From: Hannah Riddle on behalf of Planning.Responses
Sent: 26 April 2022 16:23
To: Planning Scanning
Subject: FW: Planning Consultation on: M/20/22/HH

Engineers Comments Regarding Surface Water Drainage

Application No: M/20/22/HH
Registered: 14th March 2022
Site Address: 48 Lane End Road Middleton-on-sea PO22 6LT
Grid Reference: 498329 100313
Description of Works: The construction of an additional storey, rear single storey extension and detached garden building.

Proposed Floor Plan
1:100 @ A3

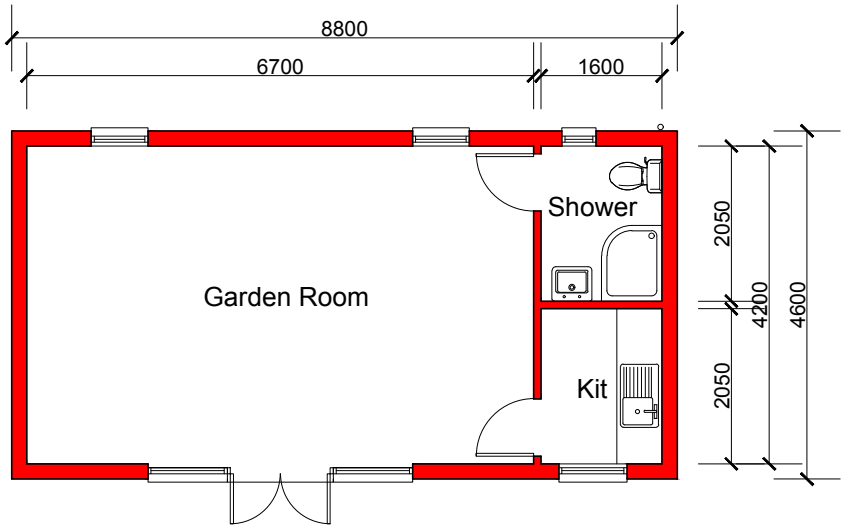
There is a watercourse on the eastern boundary of the site and the location and block plan show the proposed garden room 2m from the watercourse. On this basis I would like to lodge an **objection** to the application. We expect an easement of 3m from the top of the watercourse bank to enable access for maintenance purposes.

Proposed Site / Block Plan
1:500 @ A3

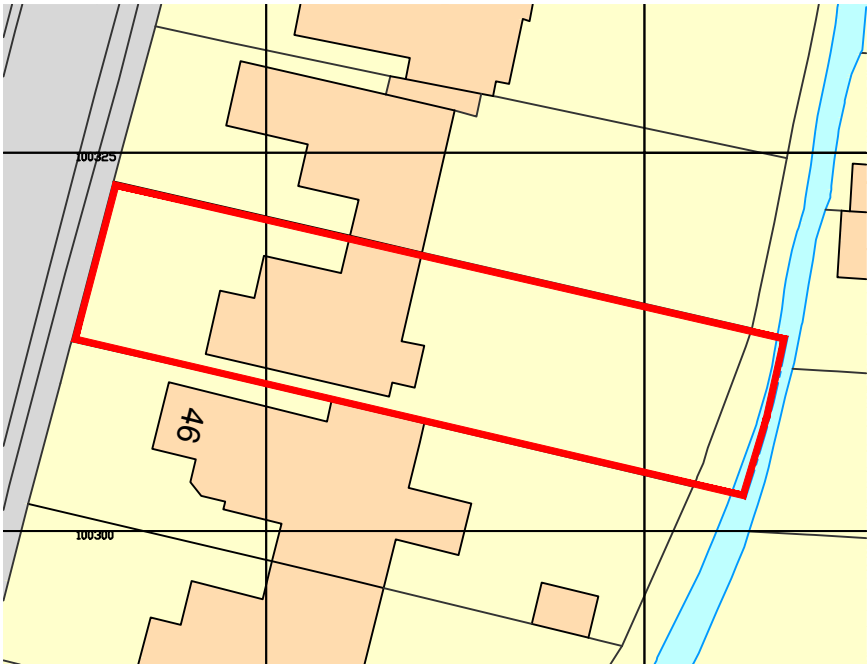
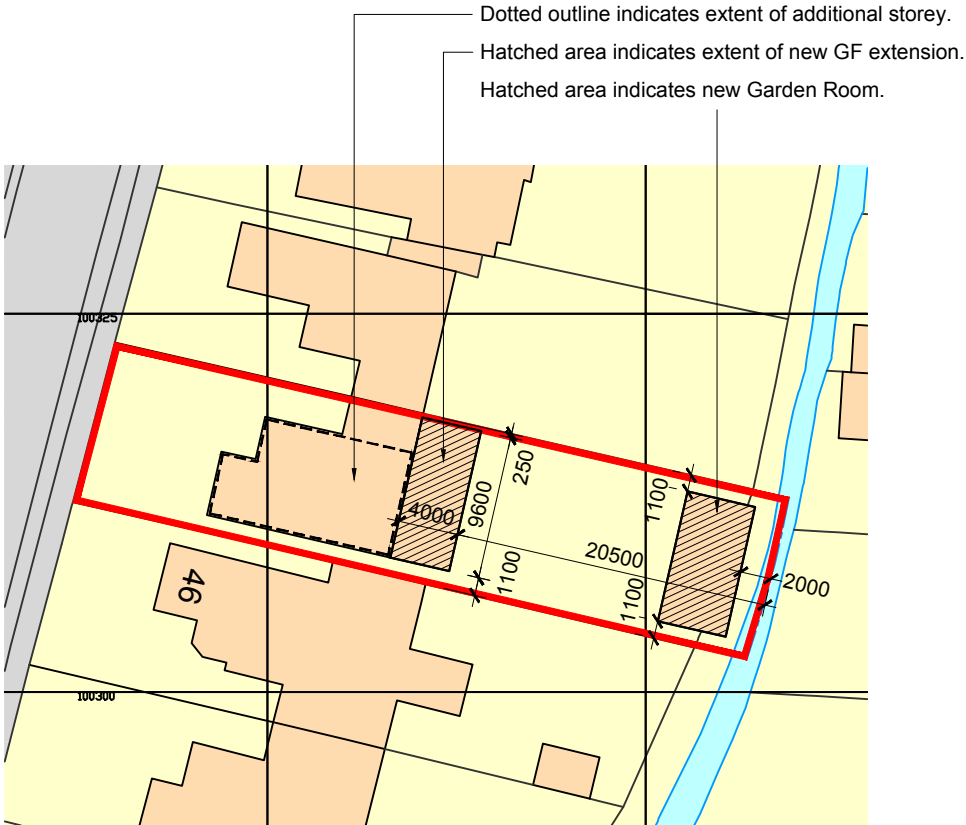
If the proposed garden room is moved 3m from the top of the bank then our objection will be lifted.
